5 May 2025

SSD-19618251 Elizabeth Enterprise Precinct – Stage 1

I refer to the Department's email of 29 April 2025 regarding the Environmental Impact Statement (EIS) for State Significant Development SSD-19618251 Elizabeth Enterprise Precinct – Stage 1 for 'Concept Masterplan including seven warehouse buildings and internal road network, with a Stage 1 development including bulk earthworks, road construction, construction and fit-out of two warehouse and distribution buildings and associated works' at 1669 - 1723 Elizabeth Drive, Badgerys Creek (Lot 100 DP 1283398, Lot 741 DP 810111) in the Penrith City Council local government area (LGA). Submissions need to be made to the Department by 29 May 2024.

SSDA MASTERPLAN - STAGE 1

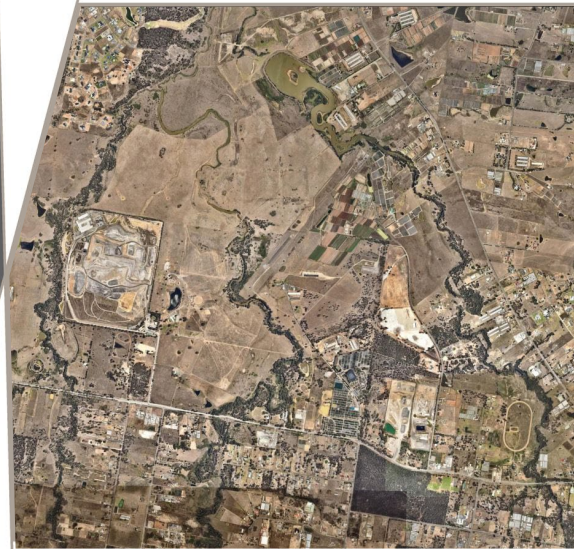
The below copy of the SSDA MASTERPLAN - STAGE 1 shows provision for padmount substations to each of the warehouse lots / buildings. Any required padmount substation/s will need to be located within the property (in a suitable and accessible location) and be protected (including any associated cabling not located within a public road / reserve) with an appropriate form of property tenure as detailed in the attached copy of Endeavour Energy's 'Land Interest Guidelines for Network Connection'.

Generally it is the Level 3 Accredited Service Provider's (ASP) responsibility (engaged by the developer) to make sure substation location and design complies with Endeavour Energy's standards the suitability of access, safety clearances, fire ratings, flooding etc. If the substation does not comply with Endeavour Energy's standards, the applicant must request a dispensation.
